From: Laura Gibbons
Sent: 13 May 2019 16:33
To: Planning.Responses
Cc: Simon Davis
Subject: RE: Planning Consultation on BR/126/19/DOC

Engineers Comments Regarding Condition 3- surface water drainage

APPLICATION NO: **BR/126/19/DOC**

Site Address: 65C Gravits Lane Bognor Regis PO21 5LN

LOCATION PLAN
65C GRAVITS LANE BOGNOR REGIS

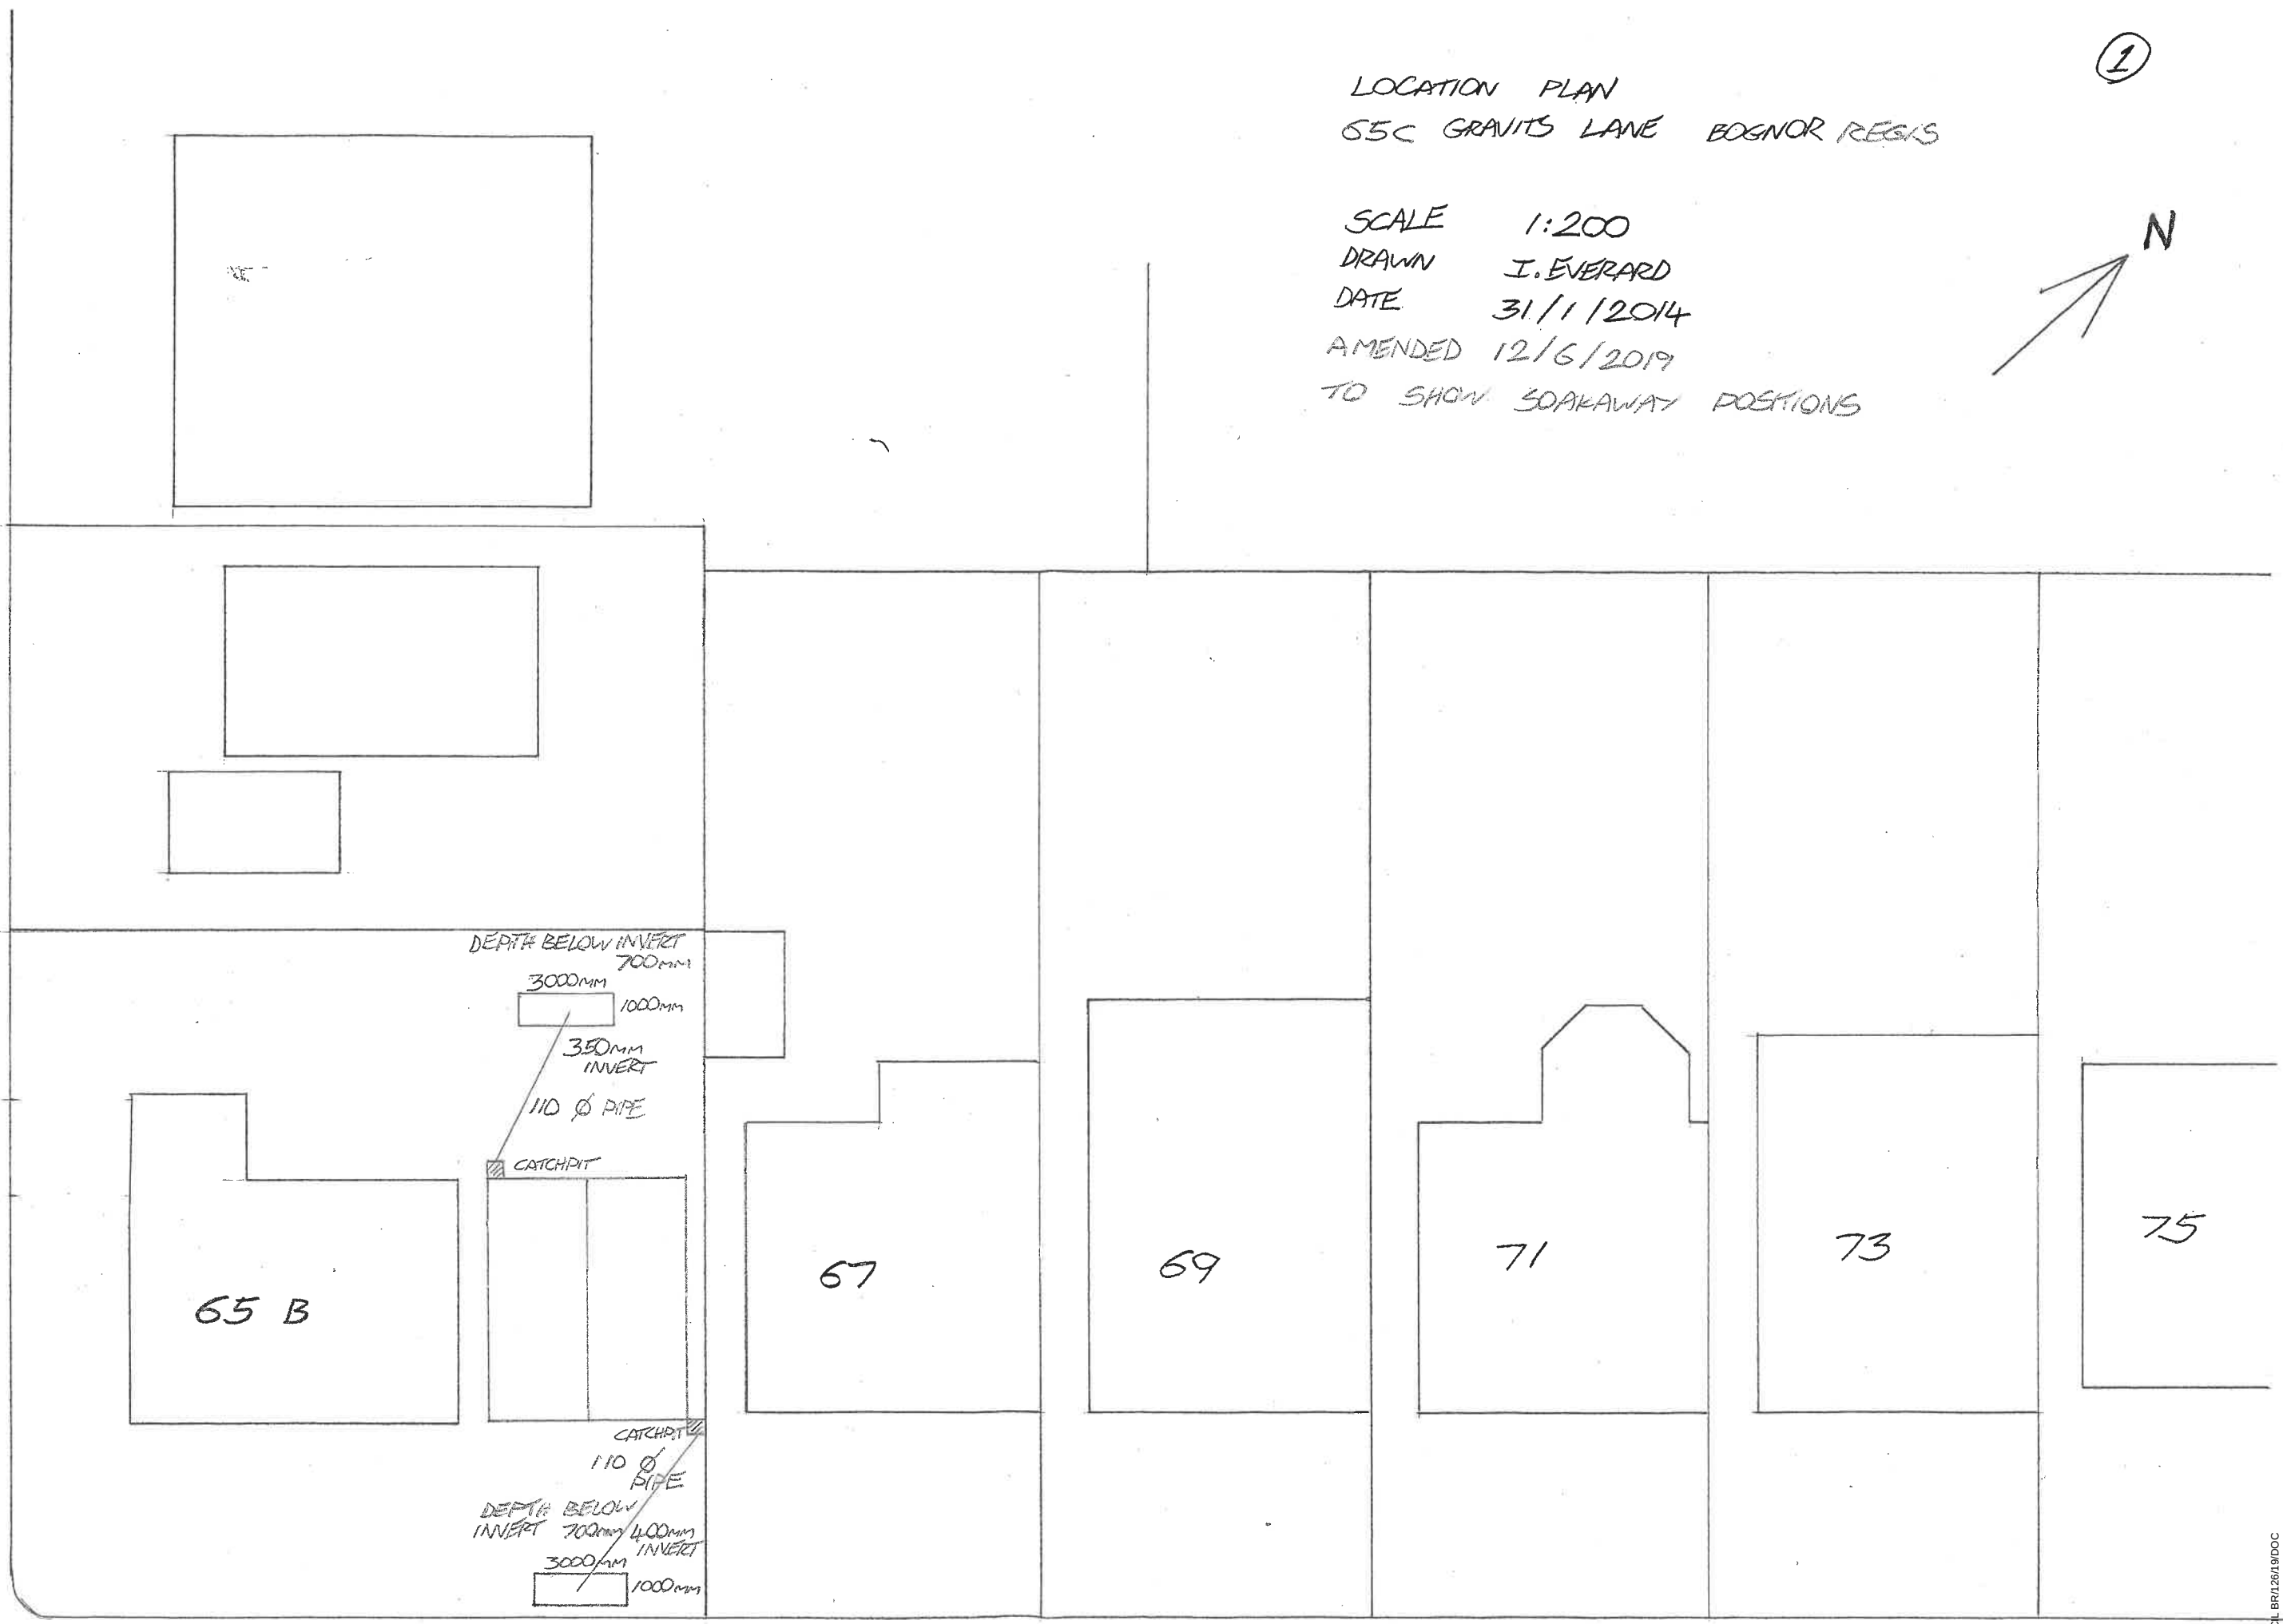
1. Insufficient storm durations have been detailed within calculations. Storm durations between 5 minutes and 24 hours should be examined.
2. Please can the applicant confirm when infiltration testing was completed, and to what depth.
3. Construction detail drawings are required.
4. Layout drawings need to be provided to scale and detailing proposed soakaway dimensions including invert and cover levels.
5. Catchpits need to be shown on plan upstream of all connections to soakaways.
